Date: 8th April 2026
To: Kildare County Council
From: RPS
Pages: 1 of 2 inc. this page
Regarding: Celbridge Hazelhatch Mobility Corridor (CHMC) – Response to RFI from An Coimisiún Pleanála re the Flood Risk Assessment Conclusion

FLOOD RISK ASSESSMENT JUSTIFICATION

aCP further information request ACP-323851-25

Figure 6-9 **Proposed Mitigation Measures**

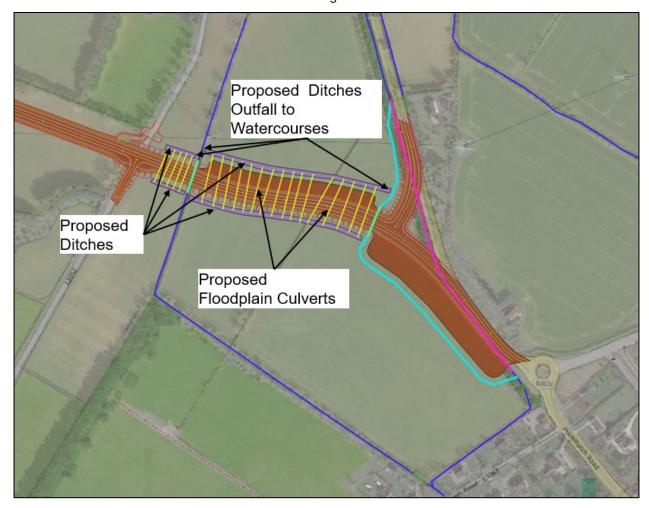
1. The Flood Risk Assessment sets out that no additional residential dwellings will be introduced into the predicted flood extents for fluvial flood events up to and including the 1-in-1000 year return period as a result of the construction of the proposed scheme with flood mitigation measures. However, the proposed development will result in a reduction in freeboard for a number of properties, therefore increasing the risk of flooding to these properties. Please address showing compliance with the Flood Risk Management guidelines and the Strategic Flood Risk Assessment of the Kildare County Development Plan 2023 to 2029.

Proposed mitigation measures include:

- 15no. floodplain culverts, Ø0.9m and 60m long each;
- 4no. ditches, 1.0m deep (500m total length);
- A downstream ditch along the CHMC alignment with outfalls to the Hazelhatch Rivers and connections for swale drainage outfalls.

Following implementation of these mitigation measures, 18no. properties on the fringe of the floodplain will experience reduced overall flood risk including all four properties to the east of the scheme identified to be within the existing floodplain.
